Re: Certification Submittal for Final Building Certificate of Occupancy for
Air-Pro, Inc., [J-14 / D51]
827 Edith NE
Engineer's Stamp Dated 07/17/07

**Re: Air Pro Inc., 827 Edith NE, Approval of Permanent Certificate of
Occupancy (C.O.), Engineer's Stamp dated 04/07/2006 (J-14/D051),
Certification dated 07/17/2007**

Re: Traffic Circulation Layout (TCL) Submittal for Building Permit Approval for
Offices and Warehouse for Air-Pro [J-14/D-51] (827 Edith), Albuquerque, NM
Engineer's/Architect's Stamp Dated 05-10-2006

**Re: Air Pro Inc. Grading and Drainage Plan
Engineers Stamp 4-7-06 (J14/D51)**

TRAFFIC CIRCULATION LAYOUT

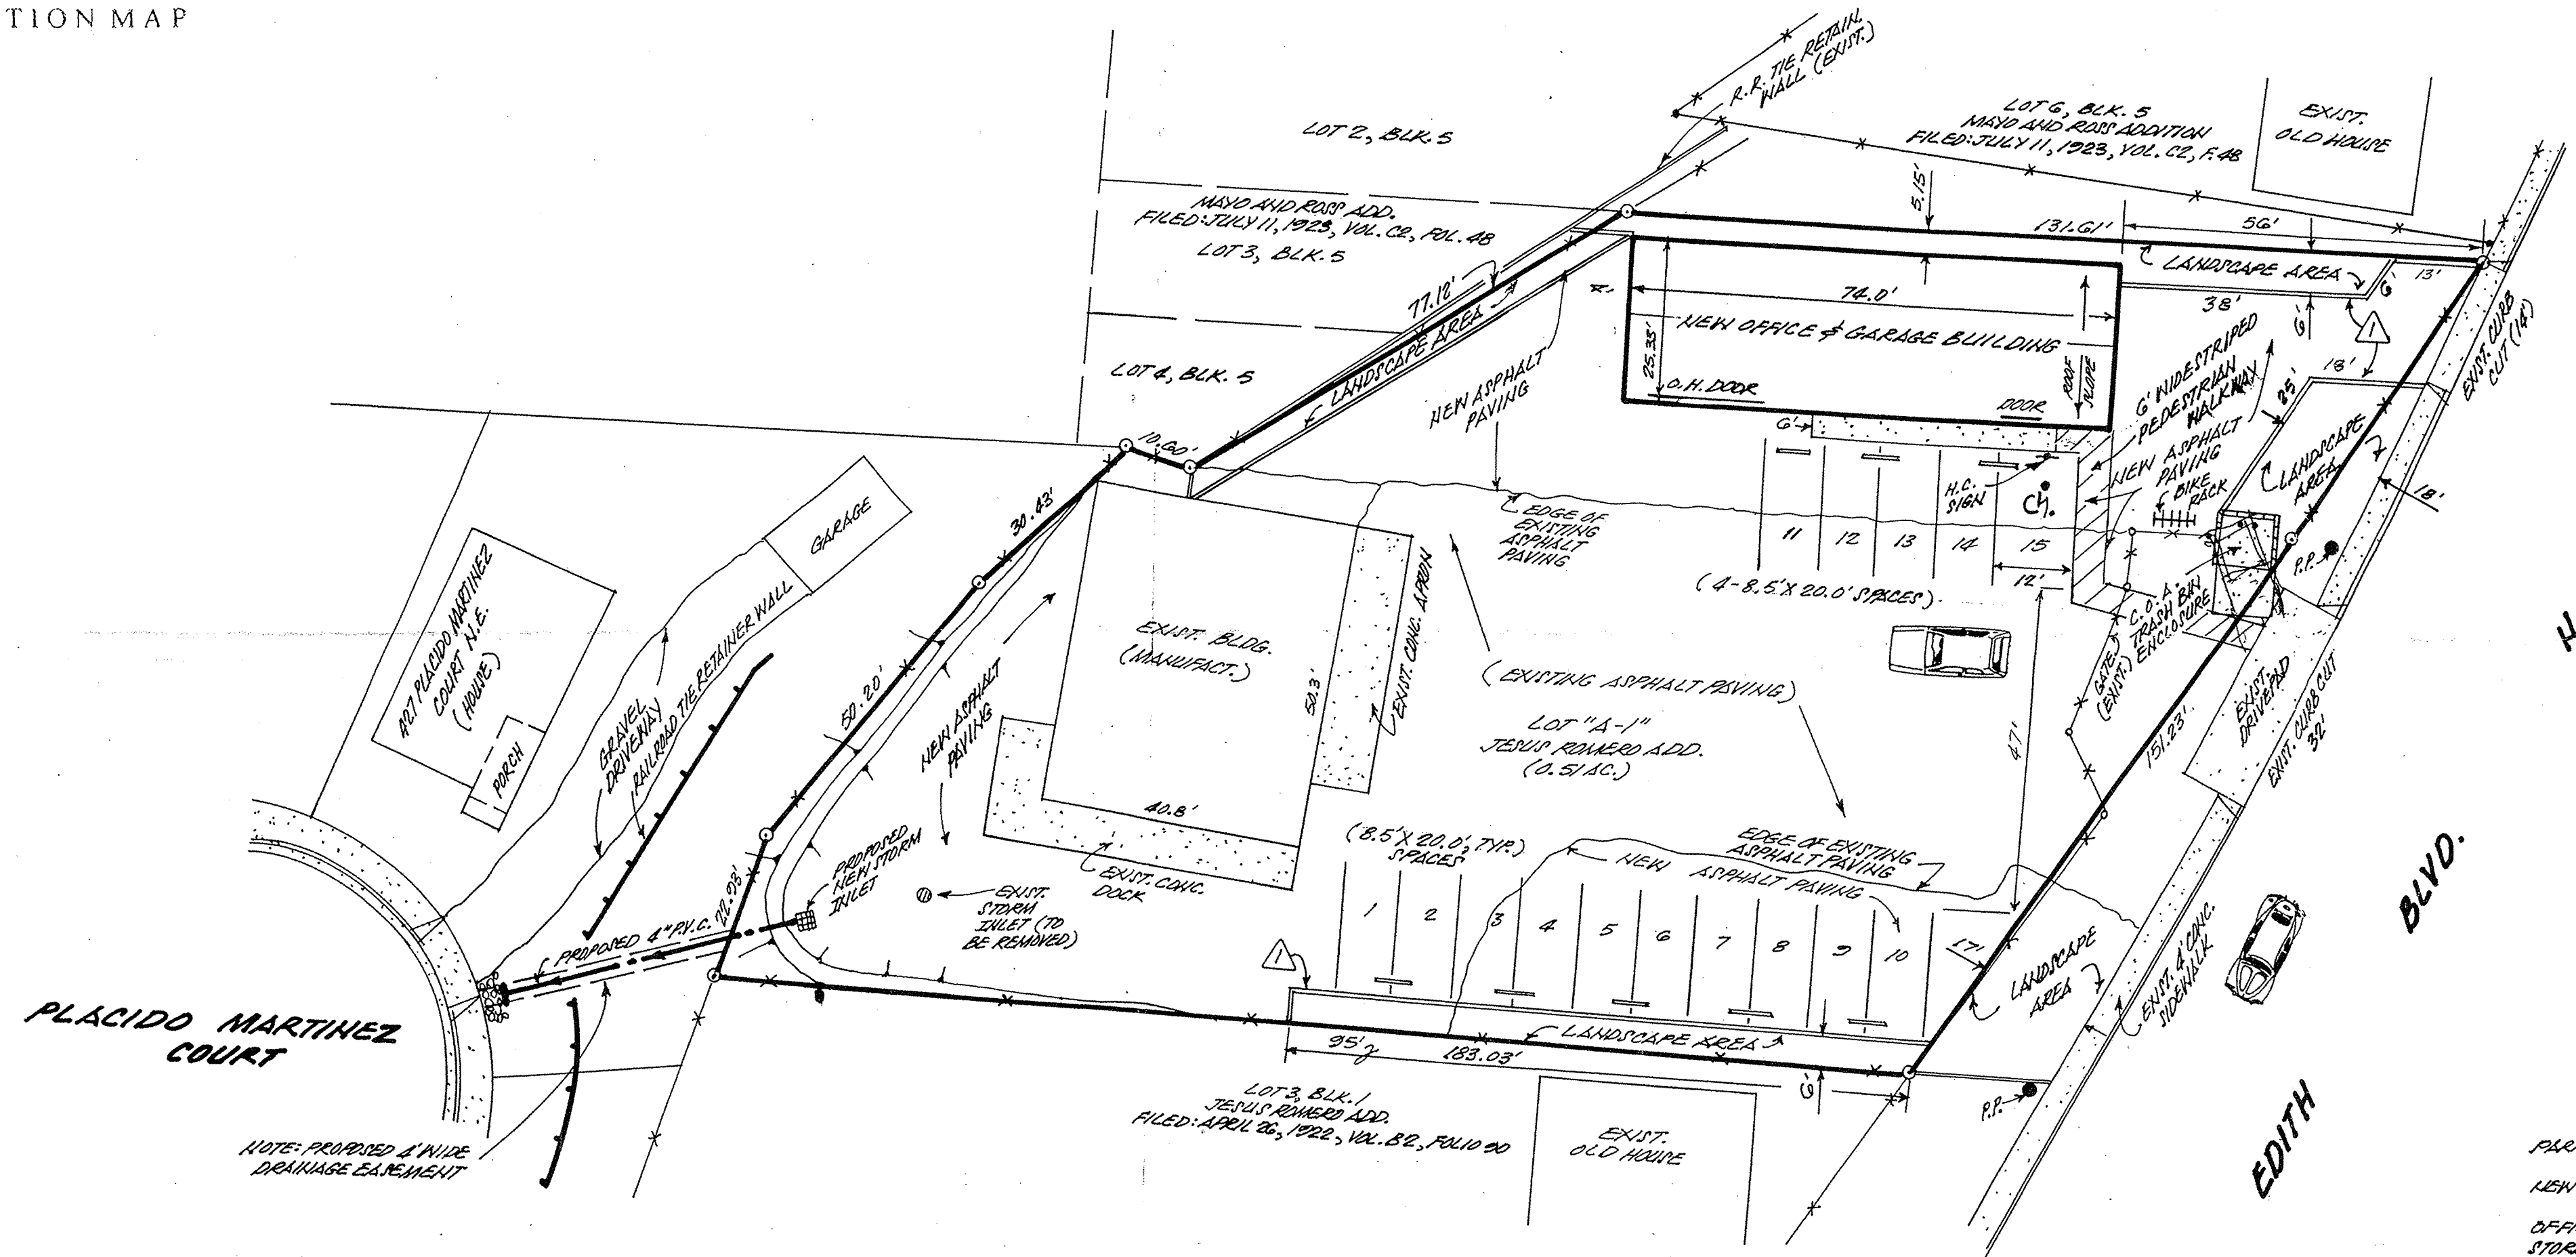
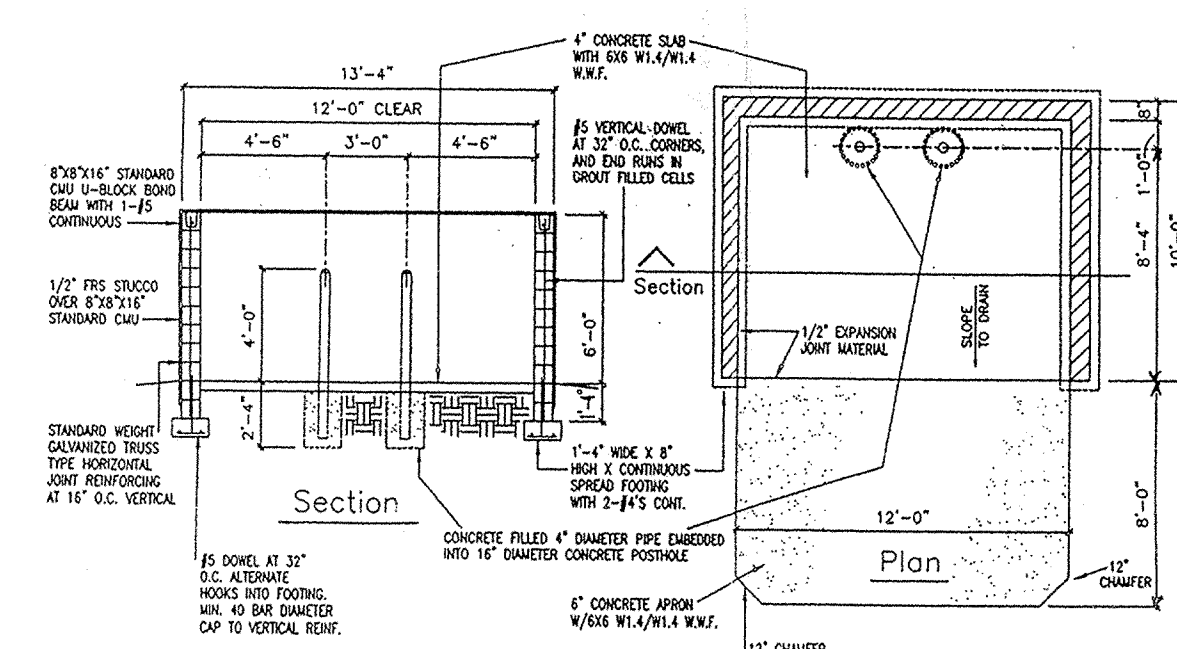
DRIVE ISLE WIDTHS?

Include solid waste approval - (out side COA Row)
